From:
Sent:
To: Igraa Malik
Subject: Request for further information R/25/21/HH

Please find attached Rev2 along with the CIL form. Please also change the description to "Glazed Gable Extension to the rear and the addition of a porch and a side extension" on our behalf.

A :: Block Plan
03 scale: 1:200

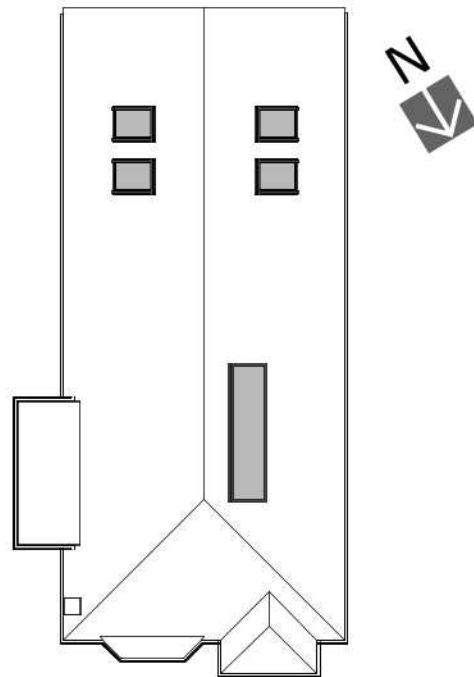
Unfortunately, this application is still invalid as the dimensions on the block plan do not measure to scale. Please review and amend accordingly.

Apologies for that! Please find attached Rev 3.
